ACP ref: 323761

I write with regard to the above planning application by Neoen Renewables Ireland Limited in relation to the proposed construction of wind energy development and all associated works.

Location: Cloondahamper, Cloonascragh, Elmhill, Cooloo, Lecarrow, Dangan Eighter, Lissavally and Slievegorm, Co.Galway.

Wind Turbine
Elevation & Plan

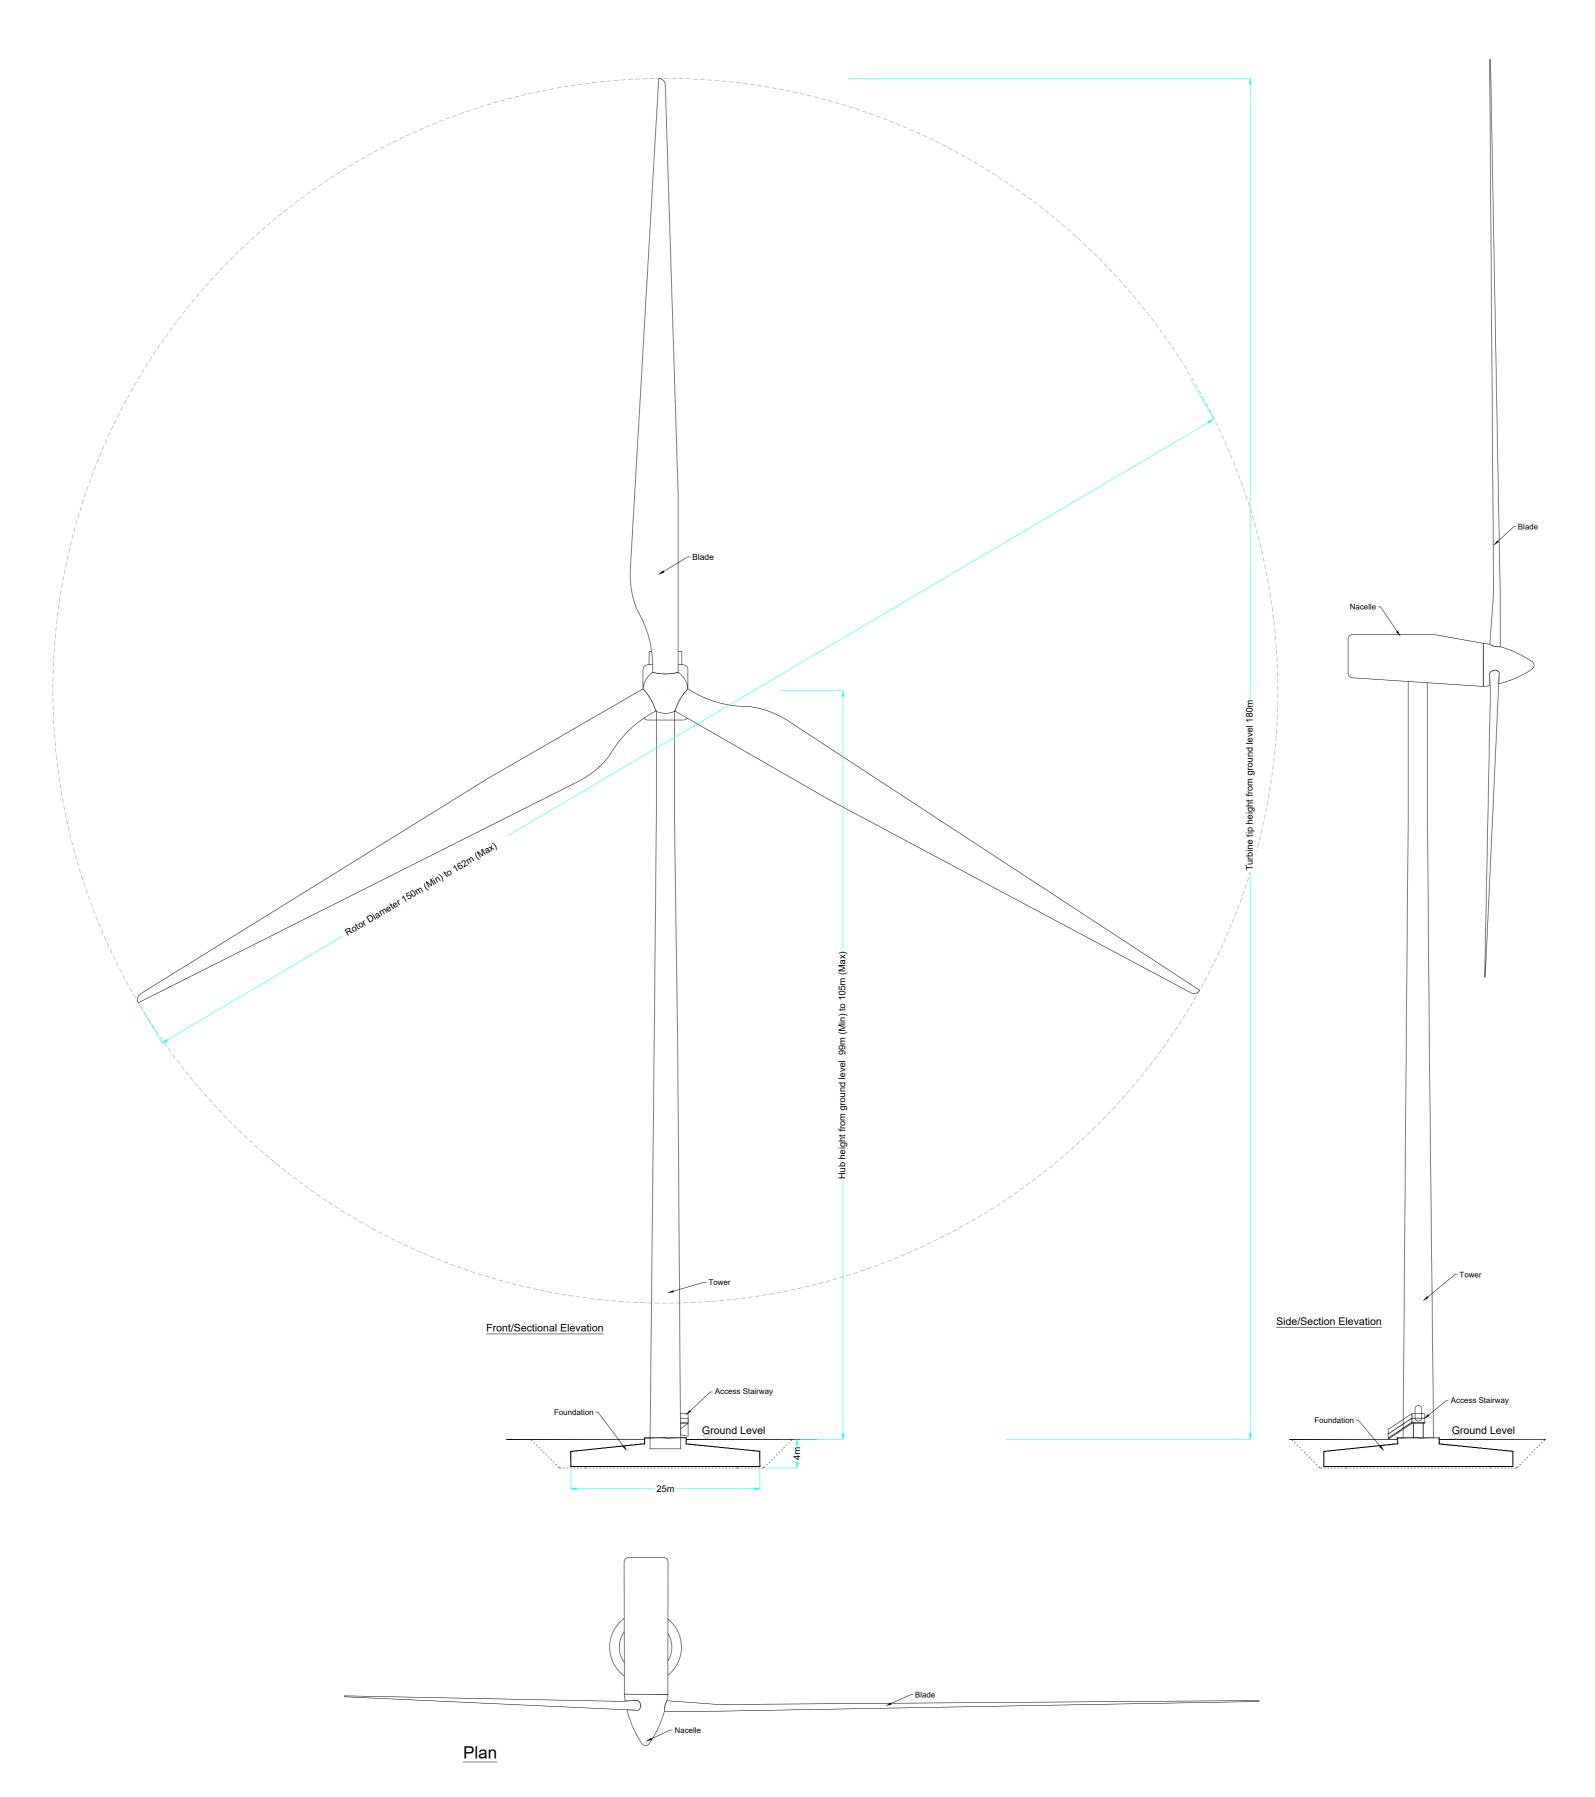
- All turbines should be illuminated by Type C, Medium intensity, Fixed Red obstacle lighting with a minimum output of 2,000 candela to be visible in all directions of azimuth and to be operational H24/7 days a week. Obstacle lighting may be incandescent. If LED or other lighting types are used, should be a type visible to Night Vision equipment. Obstacle lighting must emit light at the near Infra-Red (IR) range of the electromagnetic spectrum, specifically at or near 850 nanometres (nm) of wavelength. Light intensity to be of similar value to that emitted in the visible spectrum of light.
- In the event of negative impacts on future military radar systems, the owner will engage with the Department of Defence and will provide suitable mitigations as soon as practical.
